From: Sarah Burrow <Sarah.Burrow@arun.gov.uk>
Sent: 14 June 2022 14:07
To: Planning.Responses <Planning.Responses@arun.gov.uk>
Cc: Anita Gardner <Anita.Gardner@arun.gov.uk>
Subject: RE: Planning Consultation on: M/42/22/PL

Engineers Comments Regarding Surface Water Drainage

Application No: M/42/22/PL
Registered: 21st April 2022
Site Address: Little Orchard 2 Sea Lane Middleton on Sea PO22 7RL
Grid Reference: 497199 100218
Description of Works: Demolition and erection of 1 No dwelling. This site is in CIL Zone 4 and is CIL Liable as new dwelling.

PROPOSED SITE PLAN

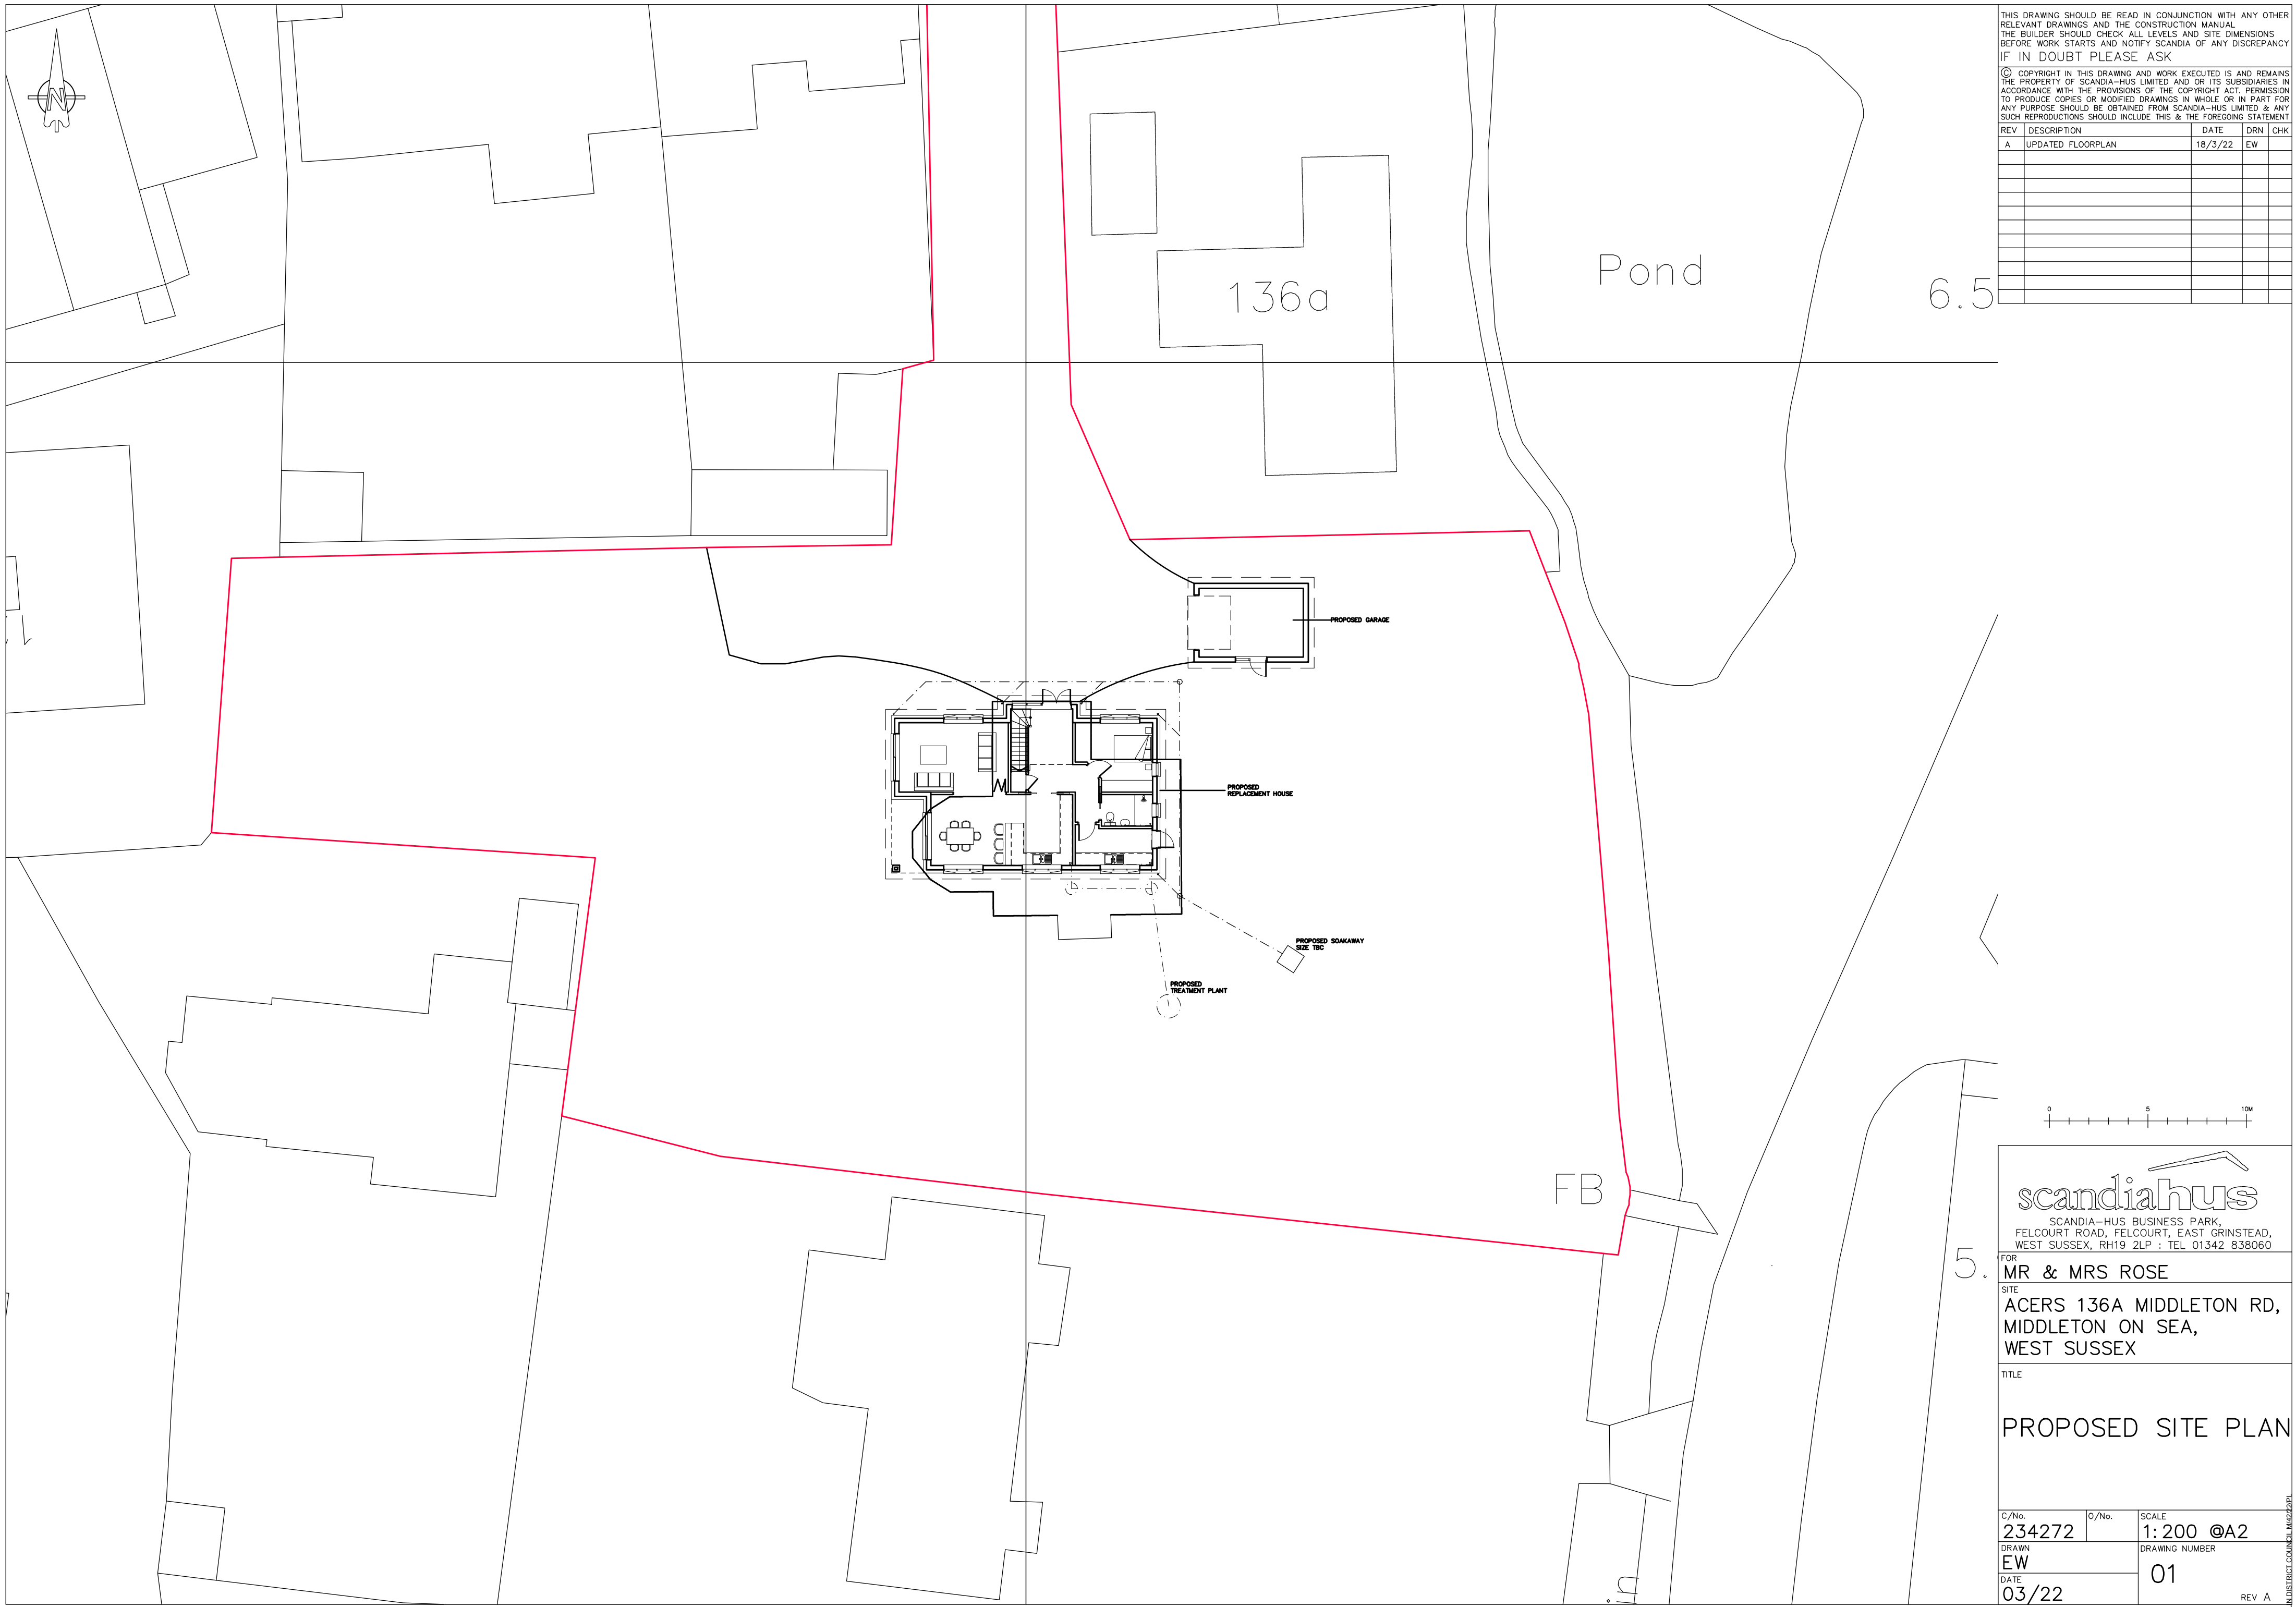
The applicant should be aware that there is a watercourse to the east of the site. If infiltration is not viable as a means of surface water disposal, the applicant will need to apply for land drainage consent to connect surface water to, culvert or make any alterations to this watercourse.
